**From:** Amber Willard <Amber.Willard@arun.gov.uk>  
**Sent:** 13 October 2020 07:42  
**To:** Planning.Responses <Planning.Responses@arun.gov.uk>  
**Subject:** FW: Planning application AL/67/20/HH

**From:** Ian Stott [REDACTED]  
**Sent:** 12 October 2020 16:04  
**To:** Amber Willard <Amber.Willard@arun.gov.uk>  
**Subject:** Planning application AL/67/20/HH

We wish to object to Planning Application AL/67/20/HH on the following grounds:-

SITE PLAN 1:500 @ A4

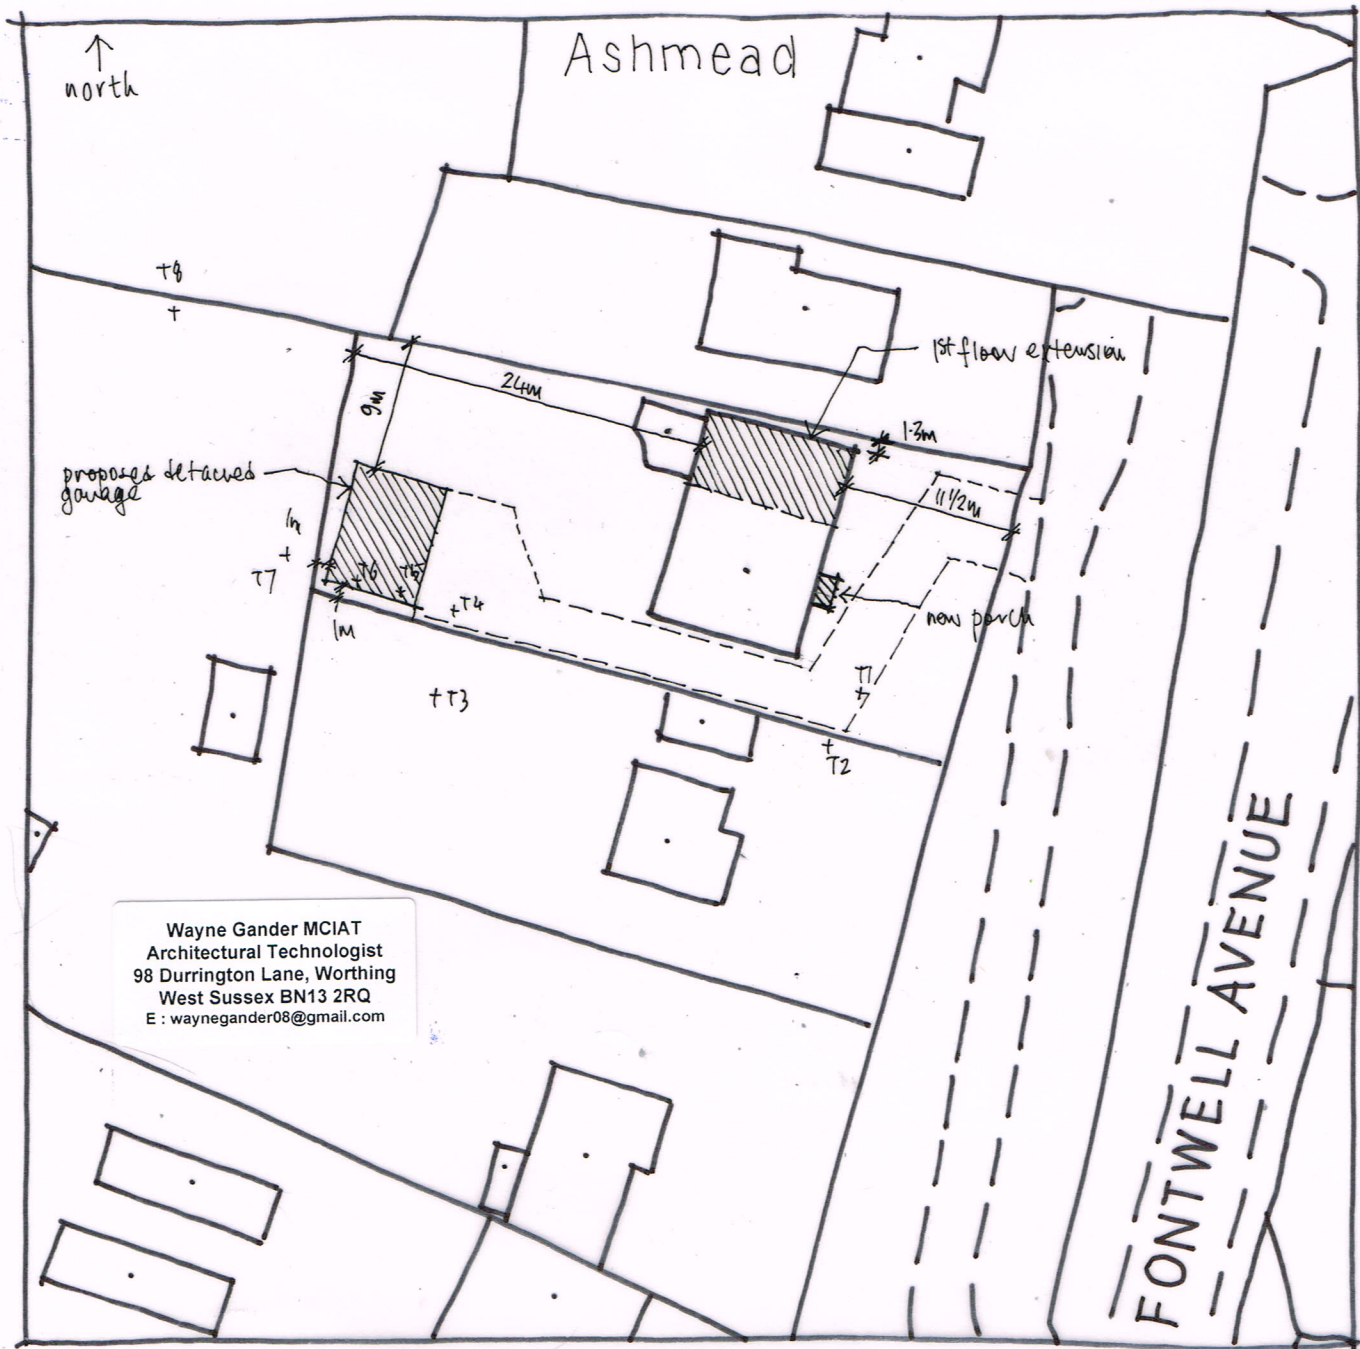
4. The proposed garage is first and foremost, in direct contravention of the covenant placed on what was formally farmland. Being a two-storey structure and on elevated land, it would dominate the landscape. The proposed structure could lead to business use, commercial use, or further conversion to domestic use. It would lead to further strain being placed on the private access road, enjoyed by the other three properties.

1st FLOOR PLAN

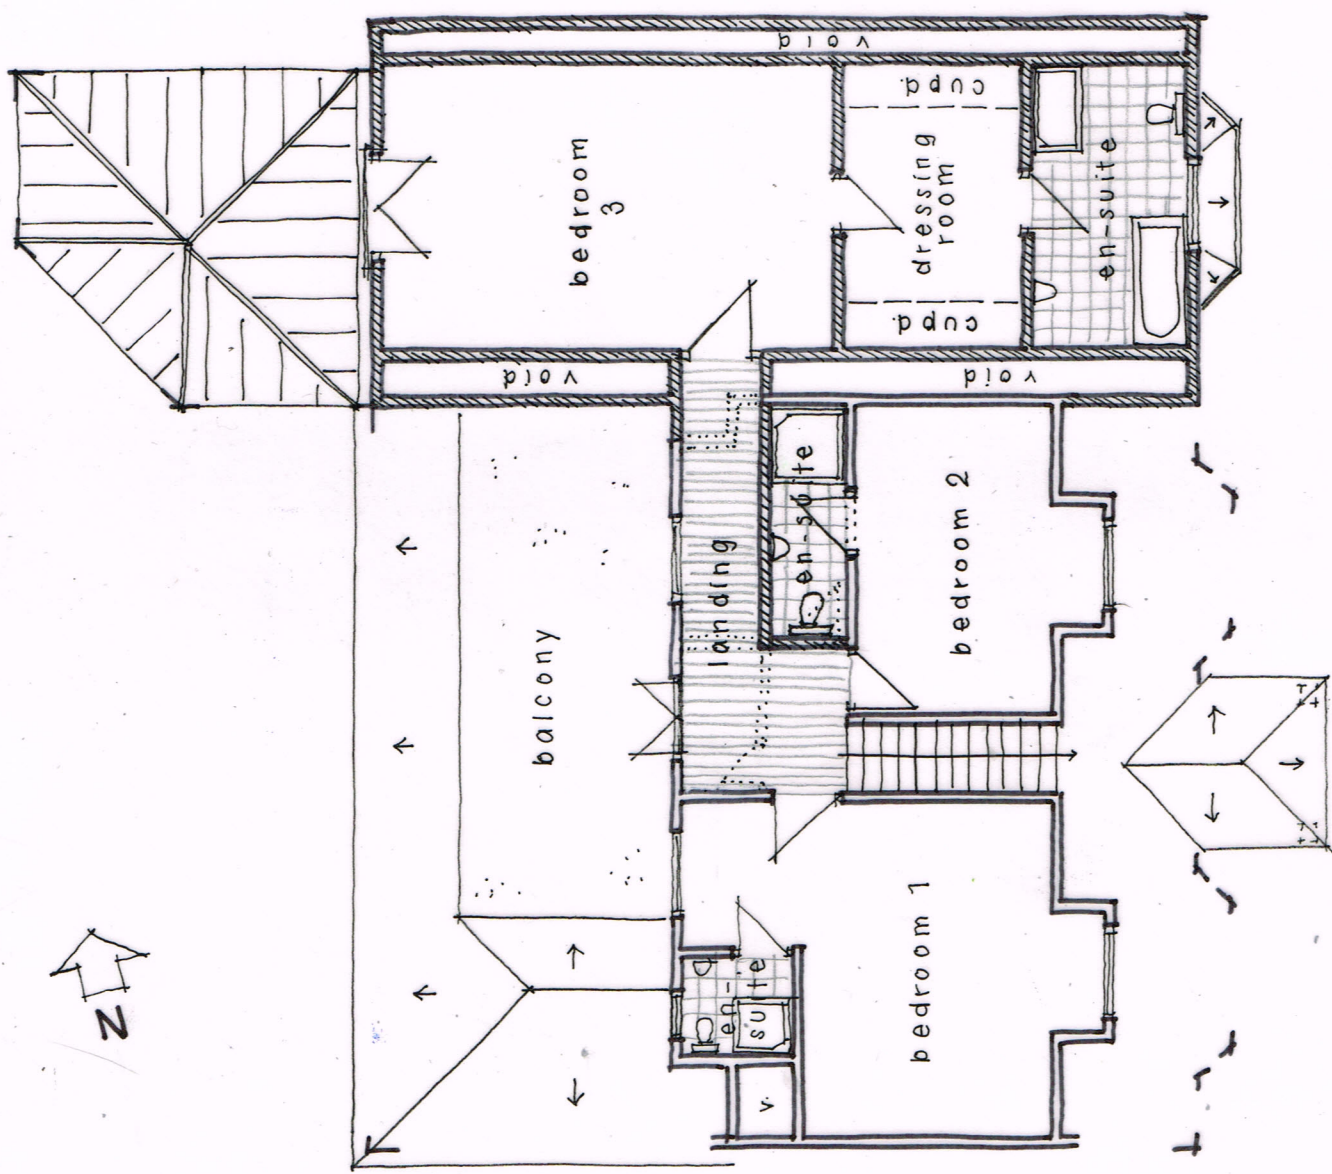
3. Allowing balconies of any type will encourage viewing of the gardens, of surrounding properties and any activities will be completely overlooked. This will impinge on the outdoor enjoyment of neighbours.

5. Also, I would question the internal layout of rooms, as to a clear exit route, in the event of a serious accident or fire.

SIDE (s) ELEVATION 1:100 @ A3

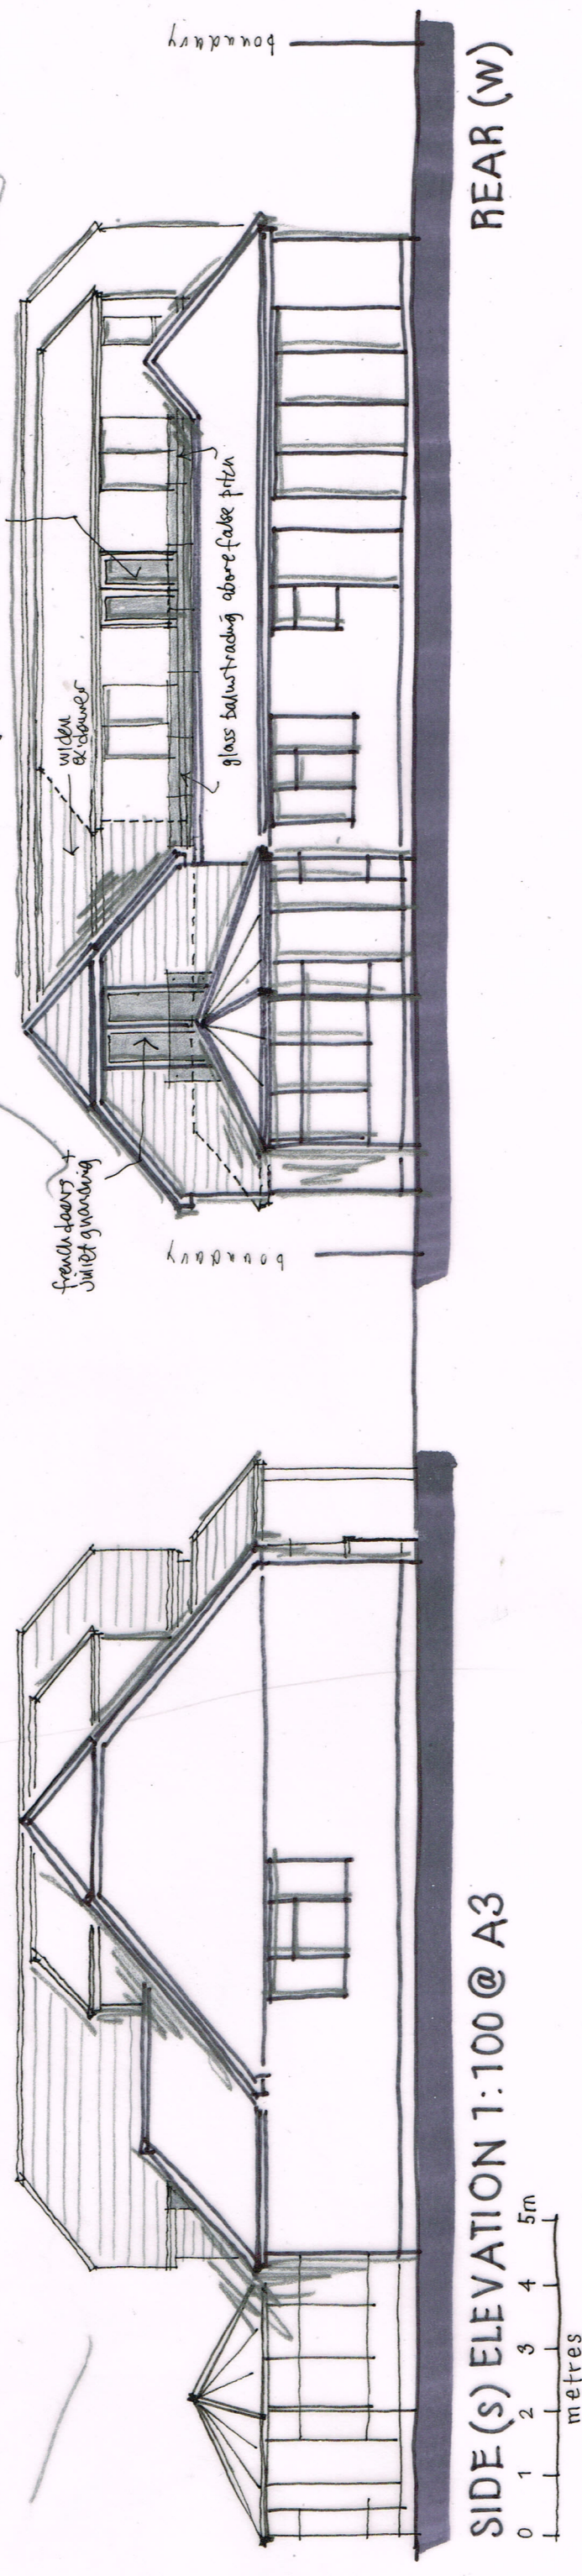
1. We see it as a gross over-development, of what was a two bedroomed bungalow, forming a row of four such properties. Extending the roof line any further, would have a grossly detrimental effect on our south facing windows, both in light and enjoyment of view, which will of course impact on the value of our property.

2. The plans show no height dimensions, and the extension which is already there, is only two feet from the boundary. Extending the roof line will only make this situation worse. It will dominate us.
